CITY OF ALBUQUERQUE

April 5, 2022

Re: Chipotle Mexican Grill
1000 Juan Tabo Blvd. NE, Suite TBD
30-Day Temporary Certificate of Occupancy
Transportation Development Final Inspection
Engineer's Stamp dated 10-11-21 (J22-D012D)
Certification dated 3-22-22

TRAFFIC CIRCULATION LAYOUT PLAN

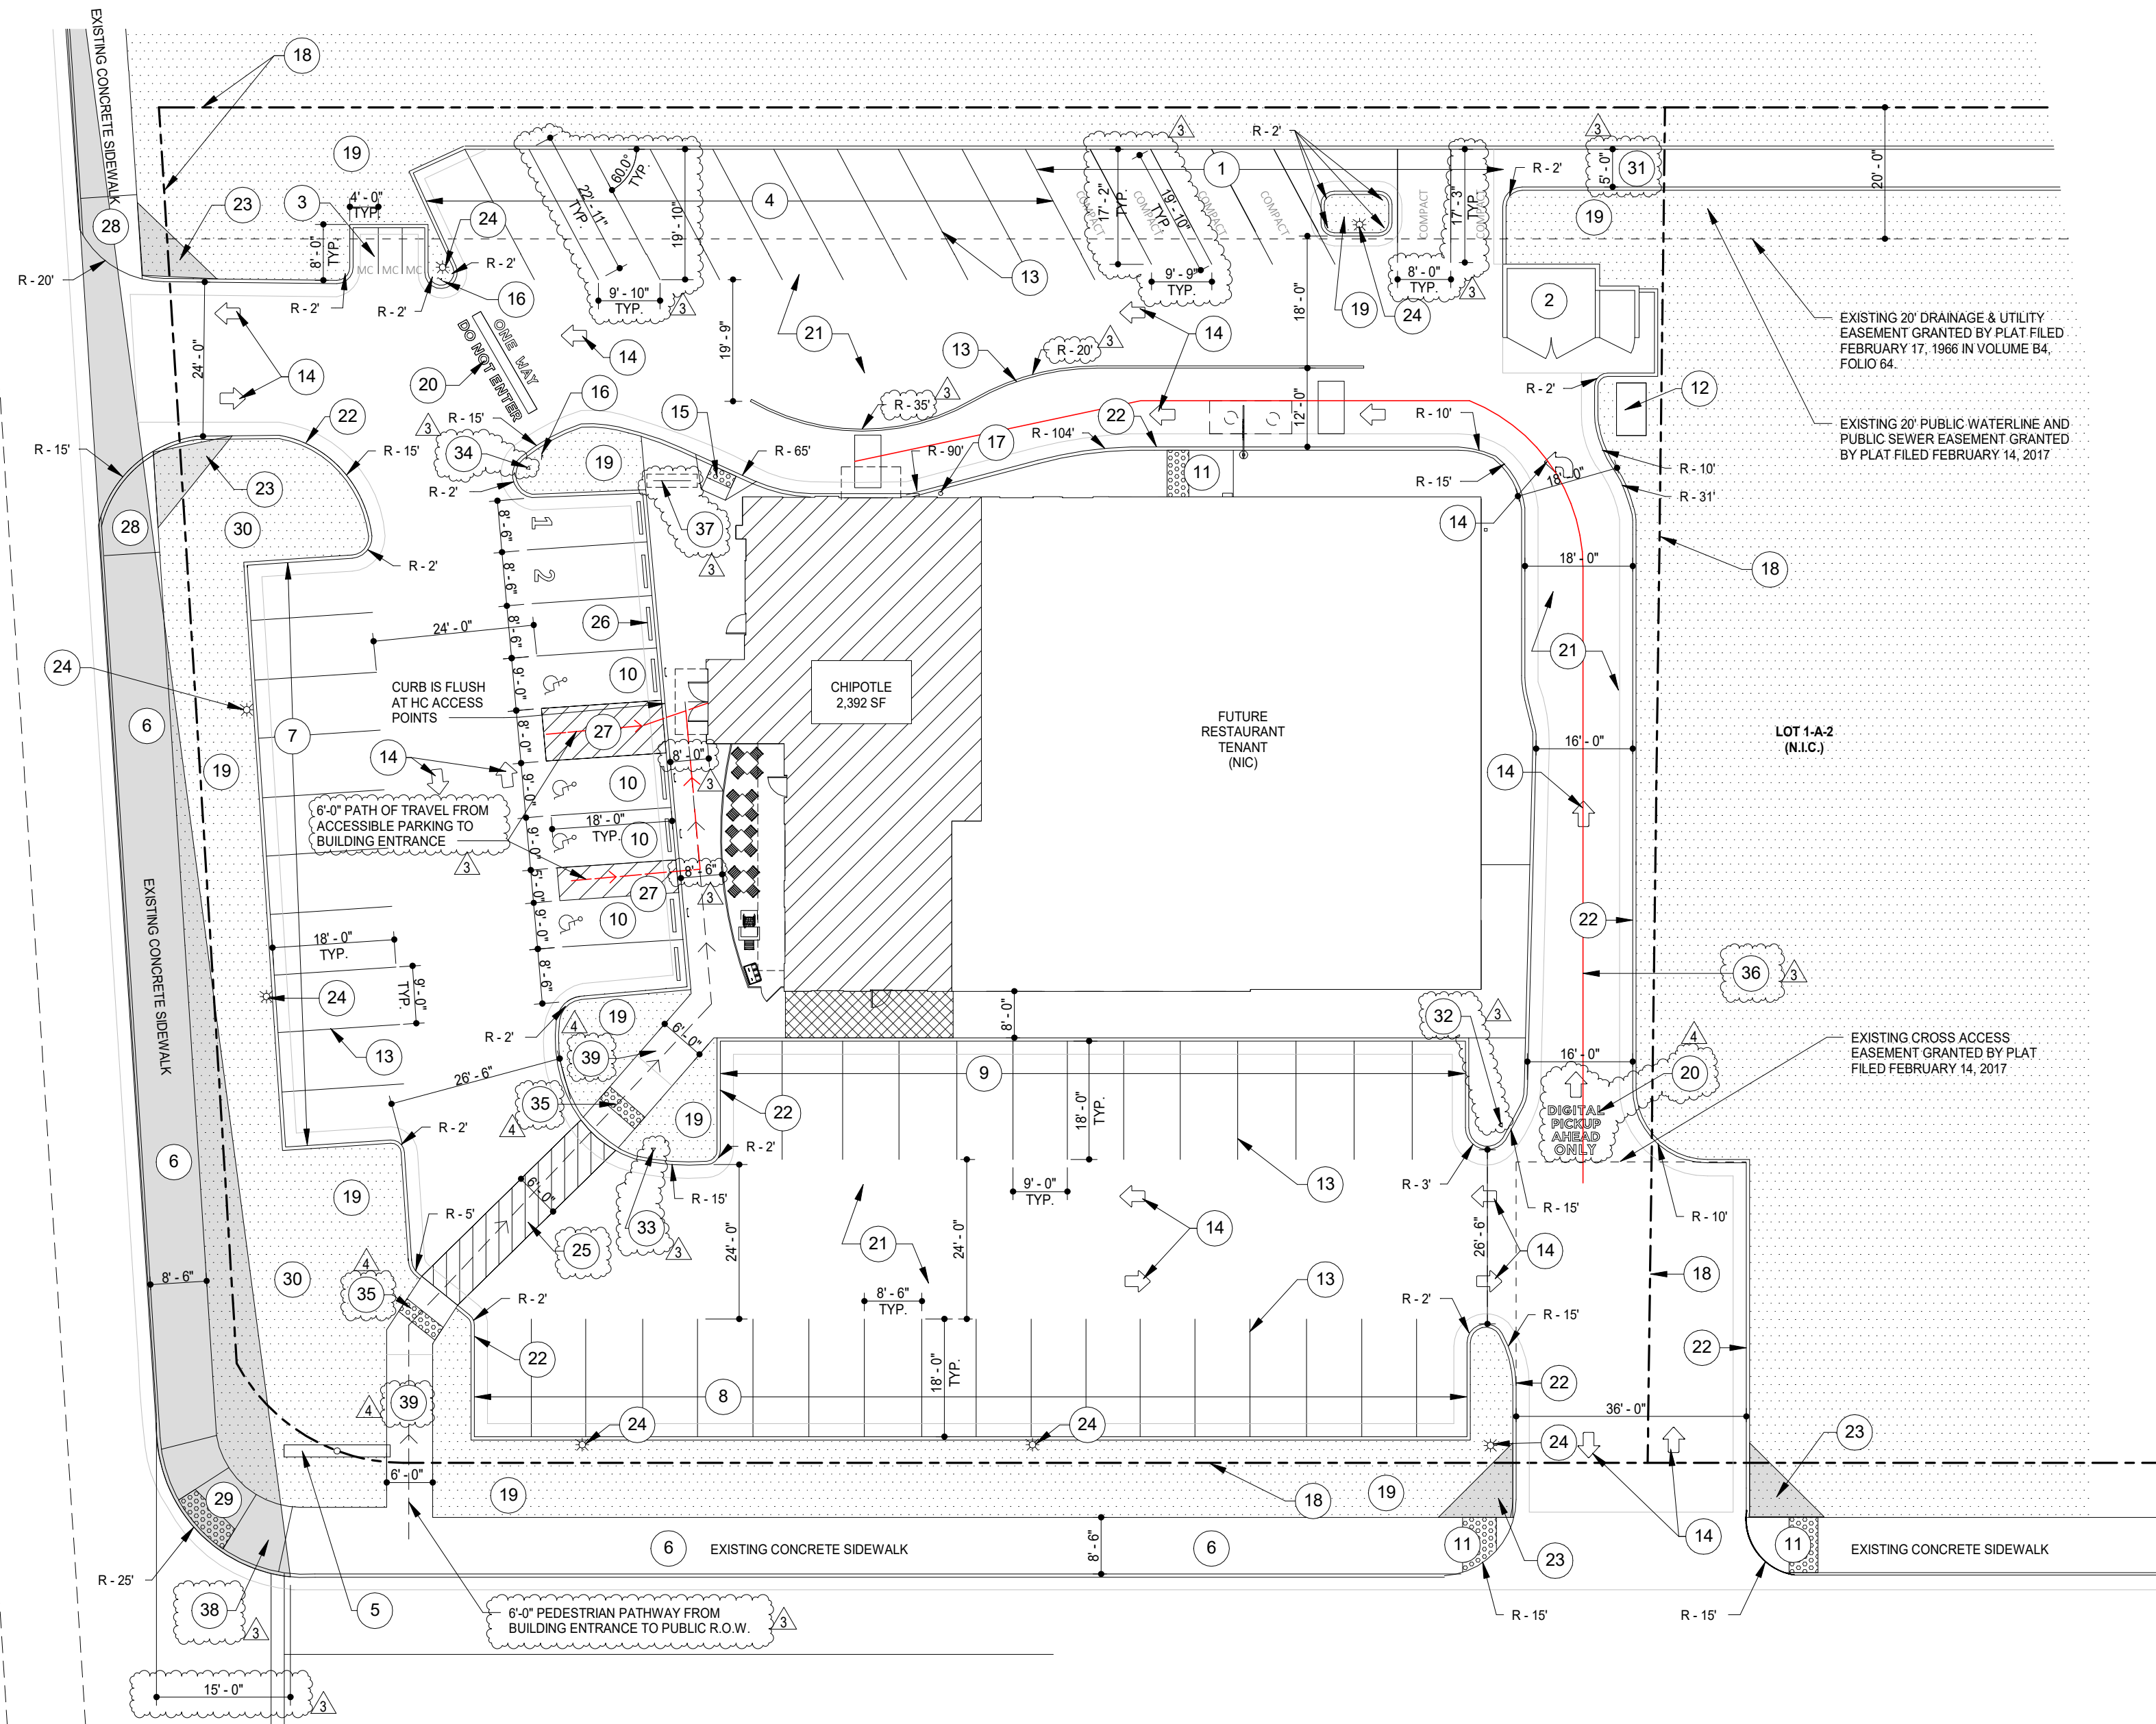
1. Key note 39 (Pedestrian path way):
 - Please fill the gap between the land scape and the path way.
 - Remove the plastic cover from the Truncated Domes.
 - The slope of the segment adjacent to the sidewalk is 5.2% to 6.2%. Please red mark the approved site plan.
2. Key note 32: per site visit, the digital pickup sign is located at the eastside of the begging of the drive-thru. Please red mark the site plan for the sign relocation.

Once these corrections are complete, email pictures to malnajira@cabq.gov for release of Final CO.
